Condition 17 - Cycle storage

Drawing No : PL_WL_500

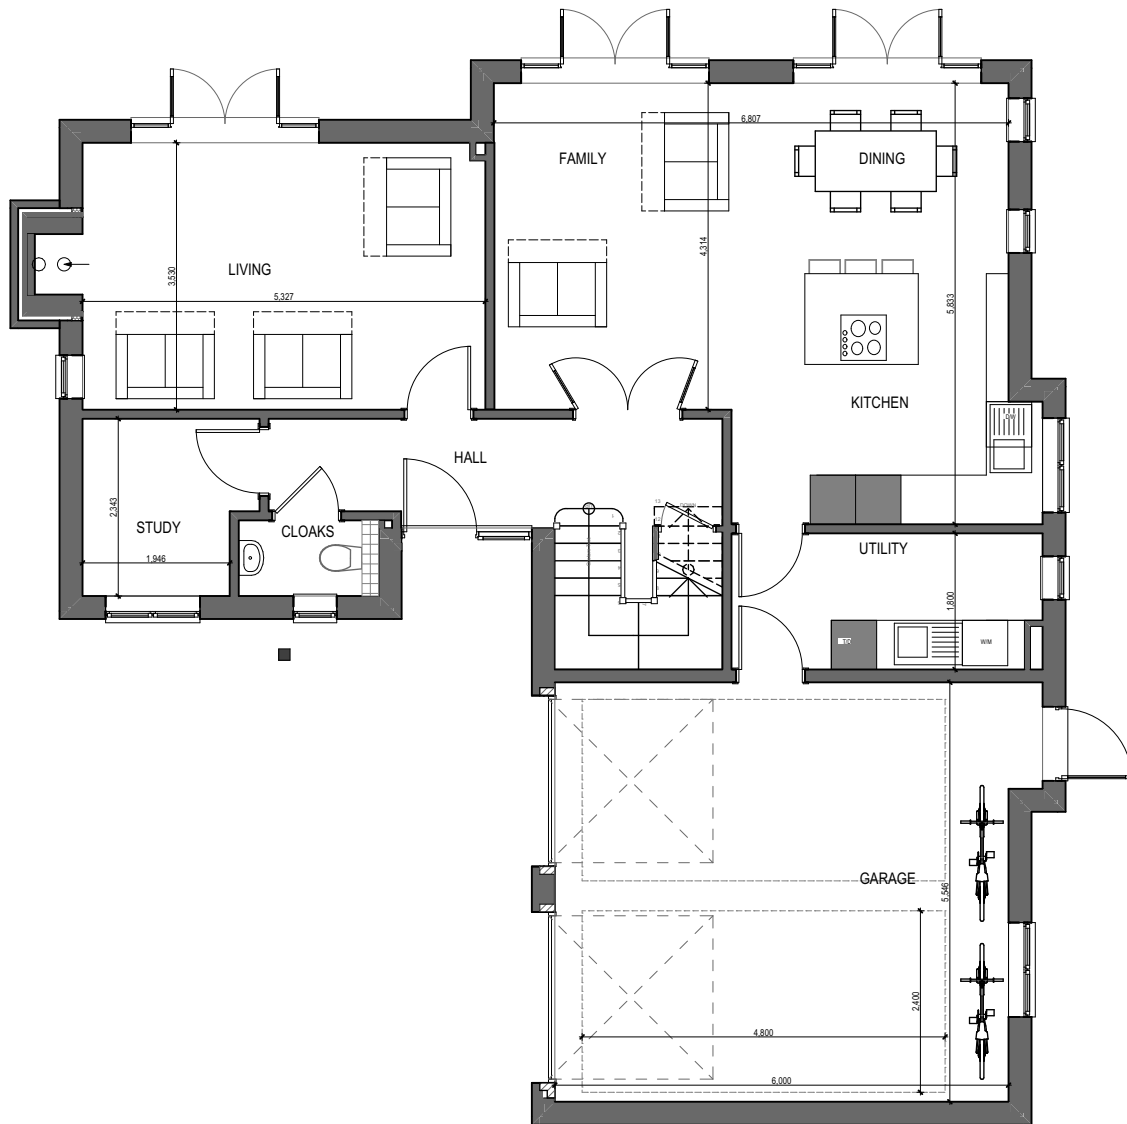
This condition requires details to be submitted. Can you provide drawings of how the cycle parking is going to fit into the garages so we have some 'details' to approve.

Please find attached drawings demonstrating garages are capable of storing cycles without impeding on a 4.8 x 2.4 area suitable for a vehicle. I trust this is suitable to allow the condition to be discharged should you require anything further please let me know.
